SUBMISSION OBJECTING TO

Residential flat building with in-fill affordable housing

35-39 Darley Street East, Mona Vale | SSD-113872990

SUBMITTER	John Dorrington	POSITION	Object
CAPACITY	Mona Vale resident	EXHIBITION CLOSES	3 August 2026

3
- 3PM
SCALE: 1:500@A3

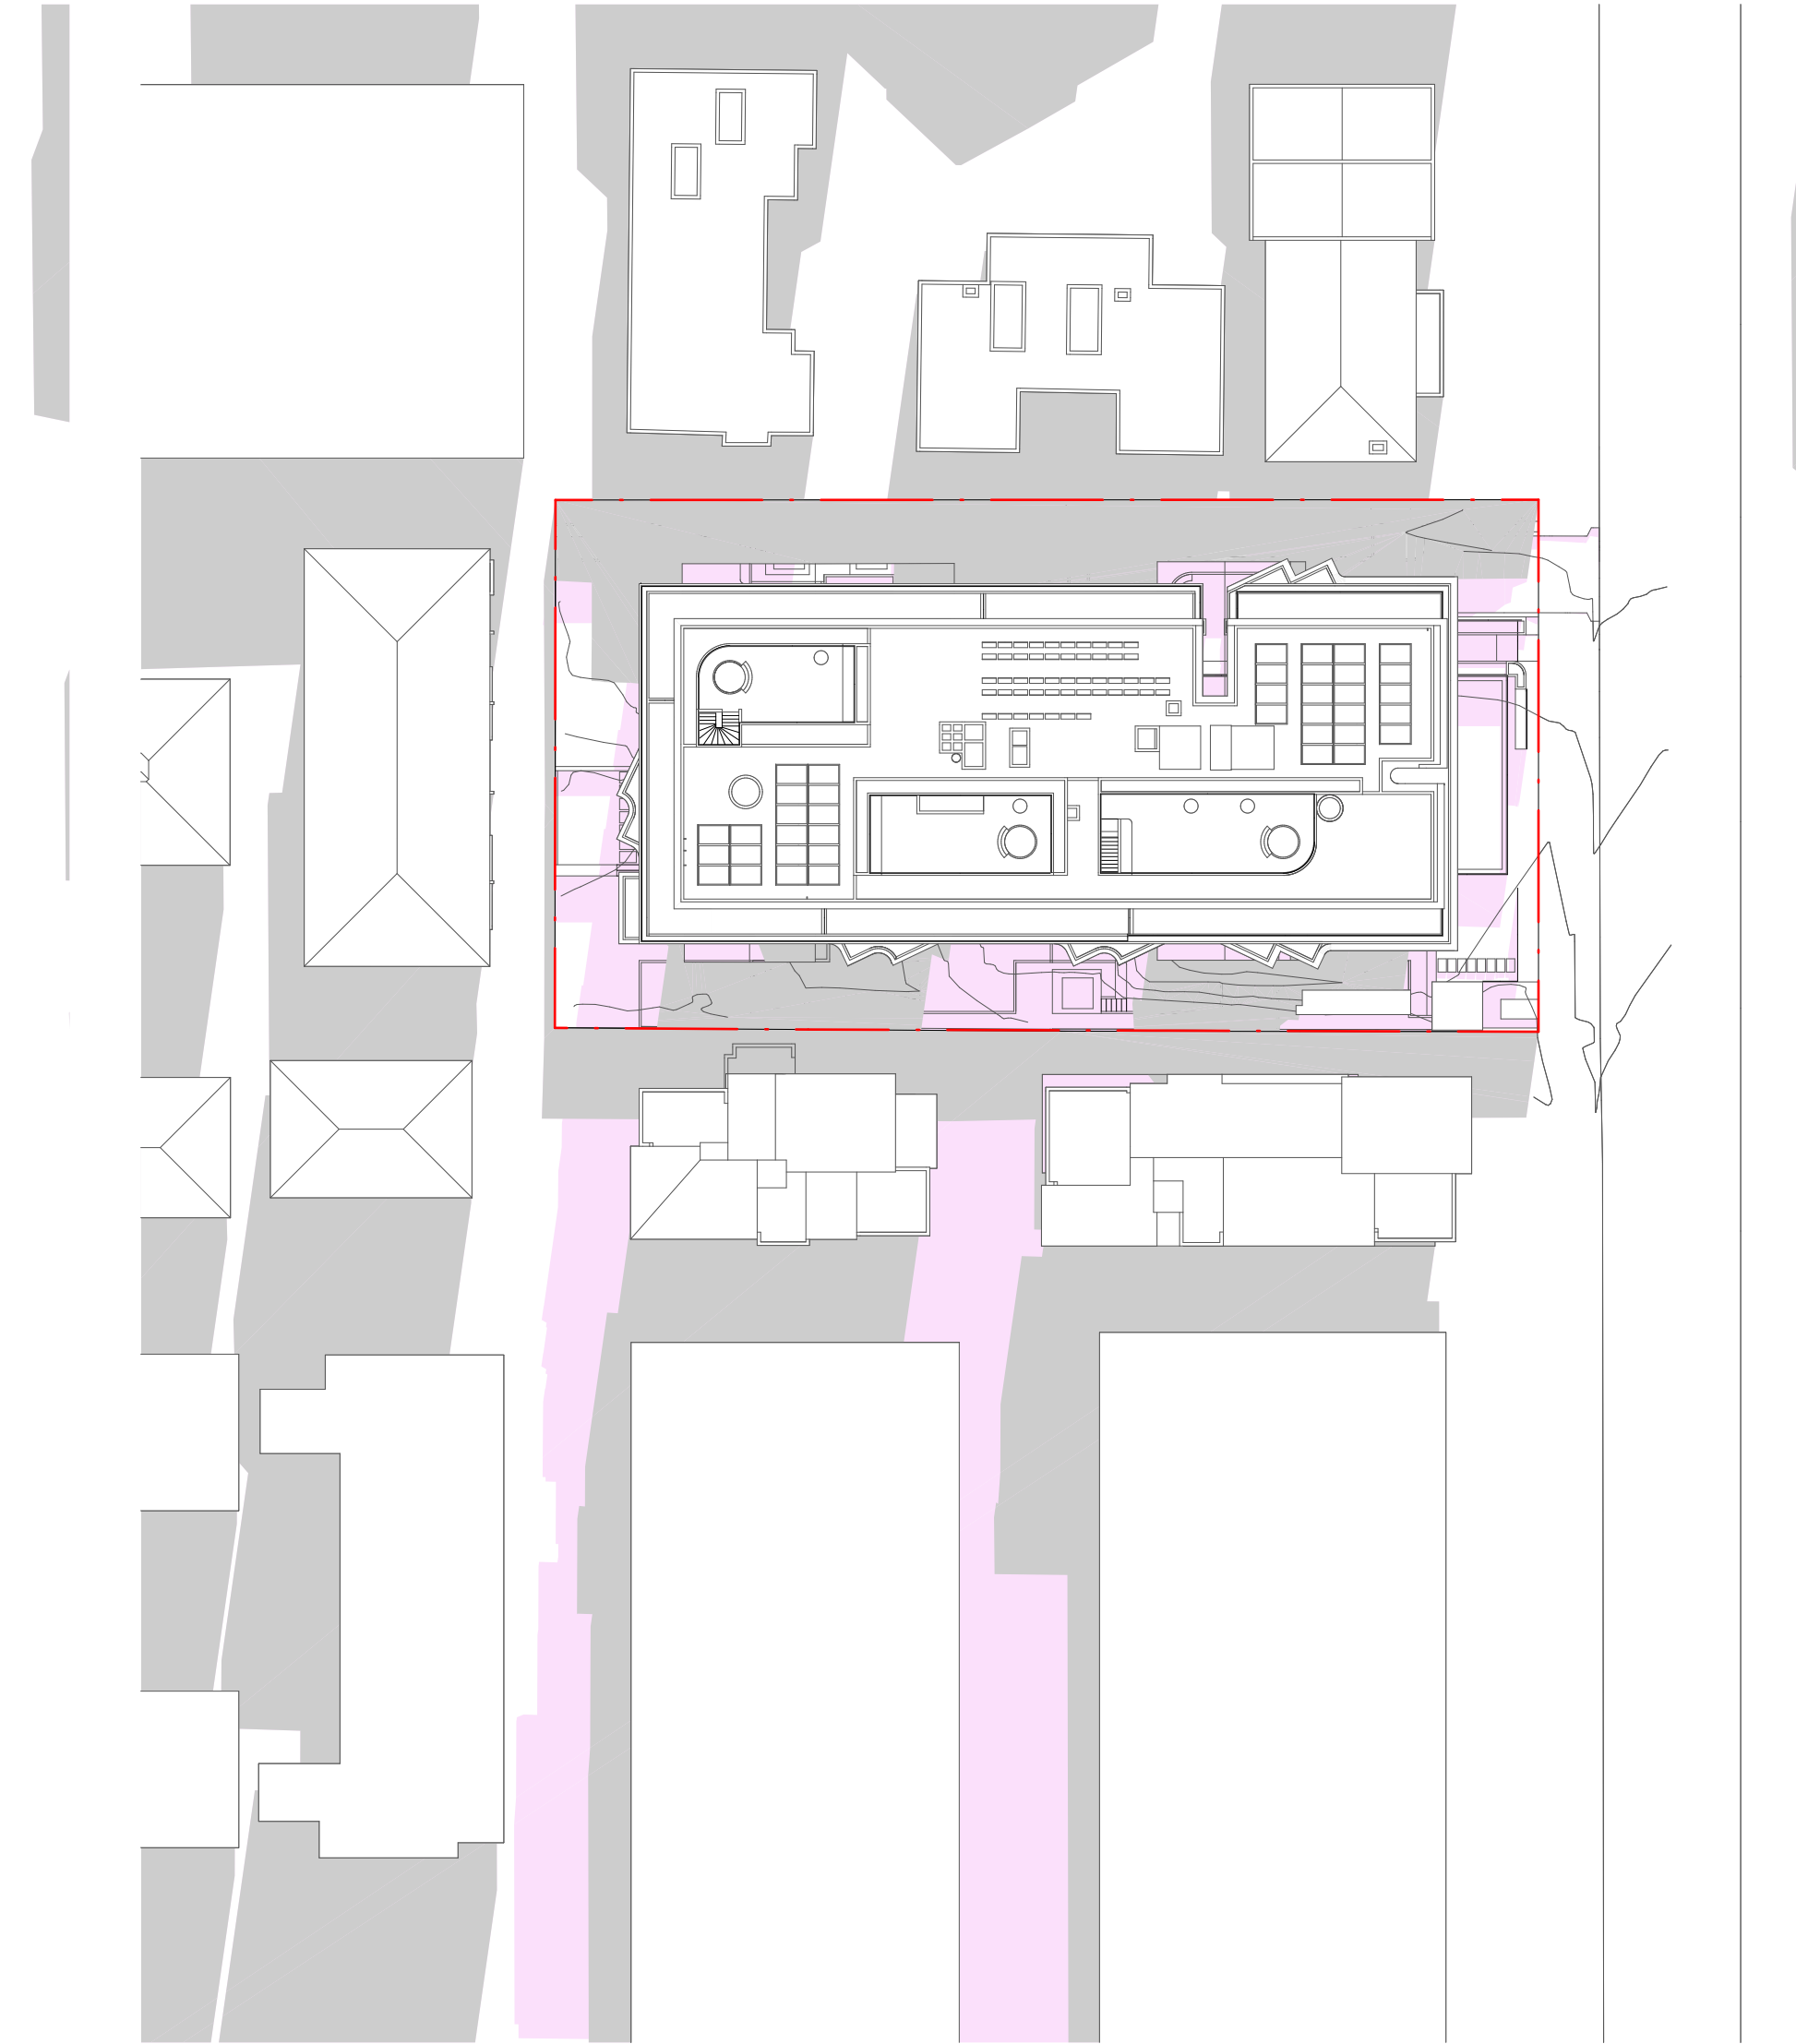
The EIS also concedes that overshadowing is unavoidable and identifies impacts to 28-30 and 32 Golf Avenue, 25-31 and 33 Darley Street East, with additional afternoon shadow extending to 34-36 Golf Avenue. Architectural shadow drawings PLA-DA-4100 and PLA-DA-4101 show new shadow extending across neighbouring land from 9 am through 3 pm on 21 June. The drawings do not support any suggestion of 'no impact'.

Before determination, the Department should require an independent peer review of the shadow model, quantified results for every affected dwelling and private open space, and a comparative analysis demonstrating the reduction achieved by deleting the upper two levels. Additional shadow should not be dismissed merely because a bonus exists.
